Rezoning Transportation Analysis
Petition Number: Insert Zoning Petition #2021-221
General Location Identifier: 04121119

From: Brandon Brezeale, PE
Brandon.Brezeale@charlottenc.gov
704-432-5561

Revision Log:

Date	Description
02-24-22	First Review (TM)
02-22-23	Second Review (TM)

6 PROPOSED SITE PLAN
SCALE: 1"=50'-0"

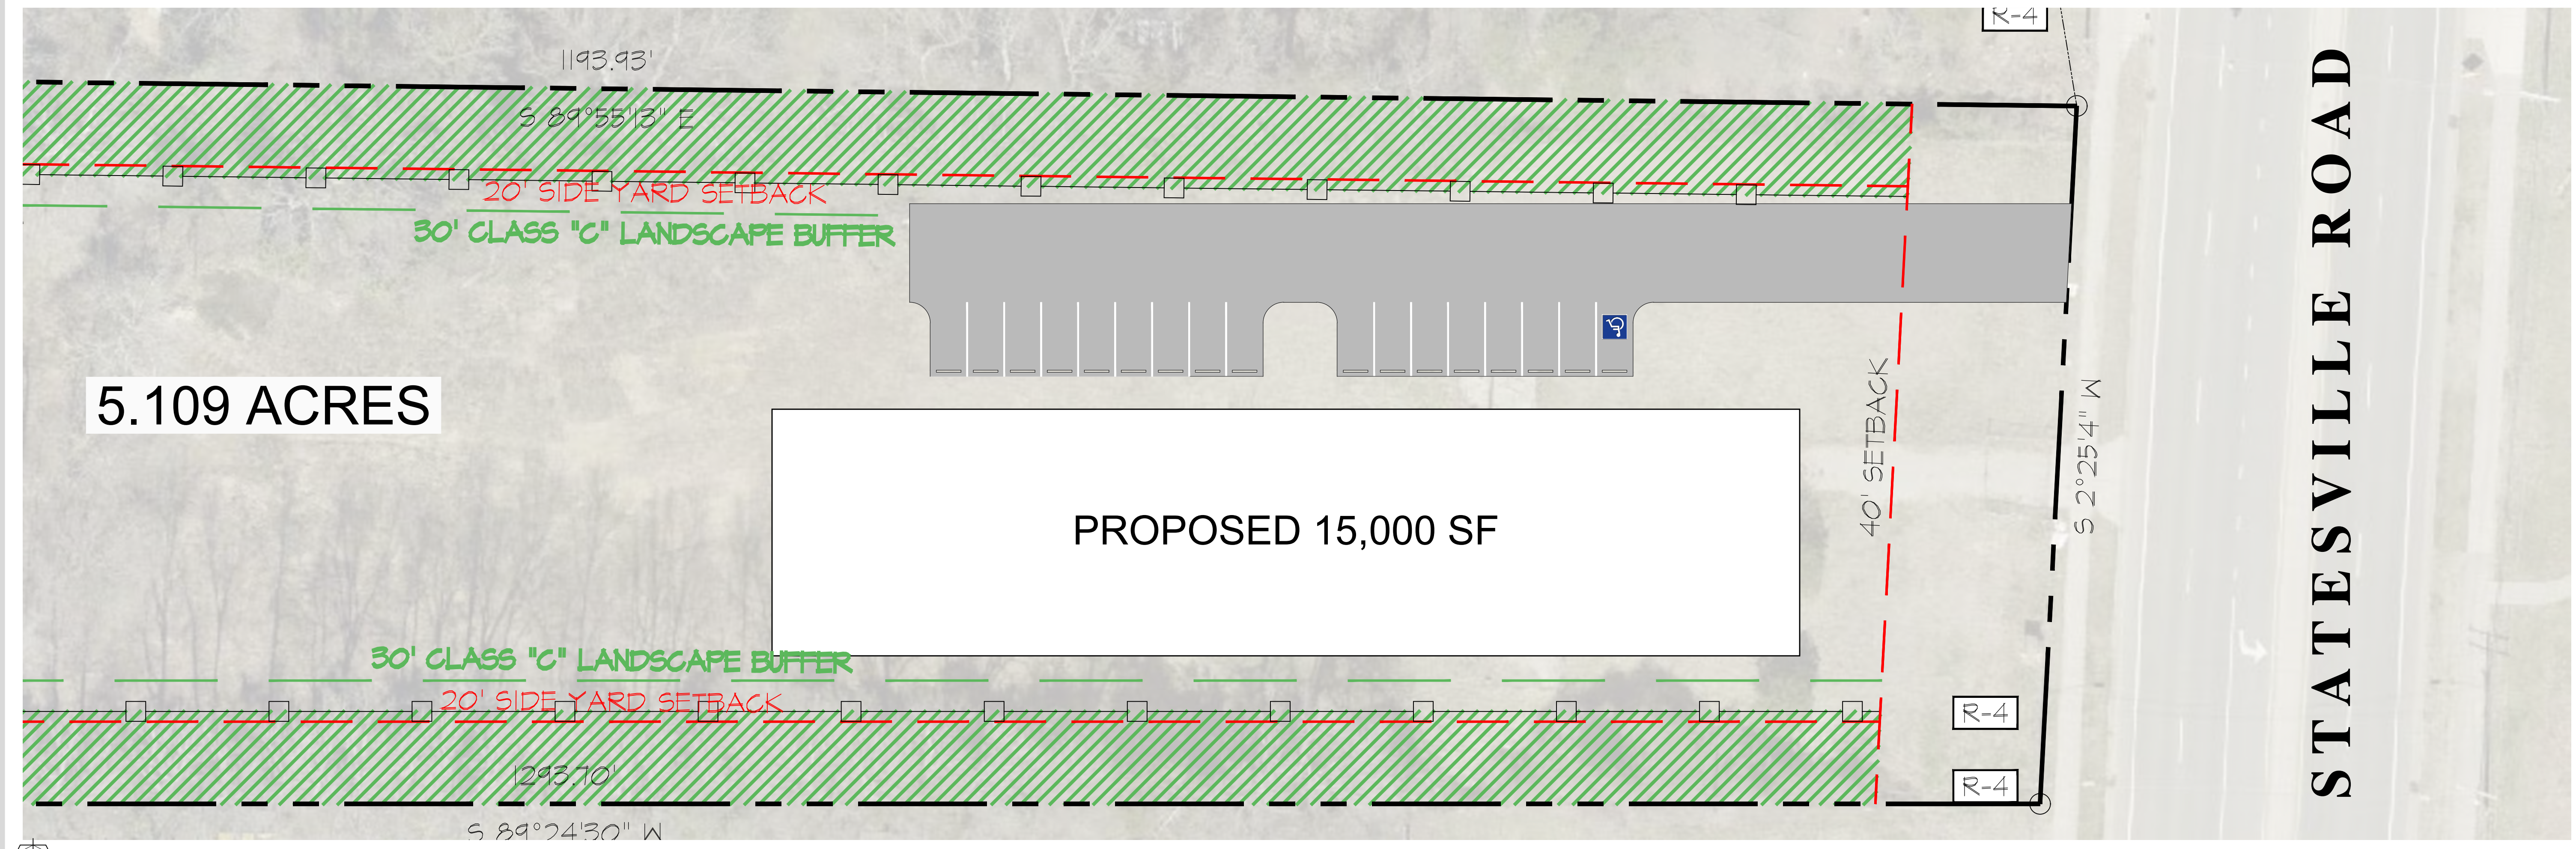
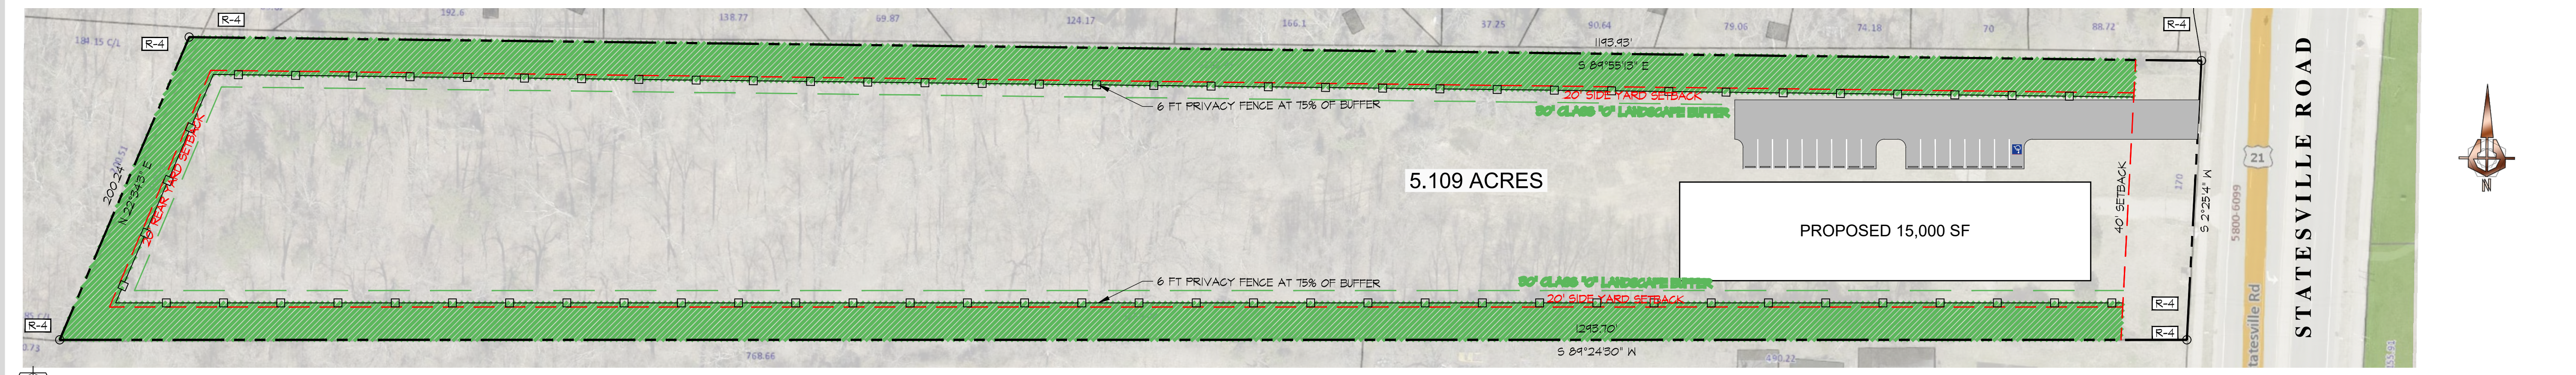
1. ~~**Curbline:** The proposed zoning district has a setback measured from back of the existing or proposed future curbline.~~
 - a. ~~**Statesville Road:** The future location of curb and gutter is in its existing location.~~

Label and dimension the curb and gutter from the centerline for each road on the site plan.

3. ~~Revise site plan and conditional note(s) to commit to dedicate 50 feet of right of way from the road centerline. The site plan shall label and dimension the right of way from the road centerline.~~
4. ~~Revise the site plan to dimension the driveway stem length from the right of way to the first parking space. A 100-ft minimum length stem length is required per the NCDOT Policy on Street and Driveway Access.~~

5. ~~Revise site plan and conditional note(s) to commit to construct a Type II Modified driveway as depicted in Charlotte Land Development Standards Manual detail 10.25E connecting to the proposed parking lot.~~

6. ~~Revise site plan and conditional note(s) to commit to construct an 8-foot planting strip, and 6-foot sidewalk on Statesville per the council adopted Charlotte WALKS policy. The site plan shall label and dimension both items from the back of curb and gutter and road centerline.~~

7. ~~Revise site plan and conditional note(s) to commit to removal of the existing driveway and replacing the curb and gutter per the Chapter 19 Ordinance requirements. Reference Charlotte Land Development Standards Manual detail 10.17A on plan.~~
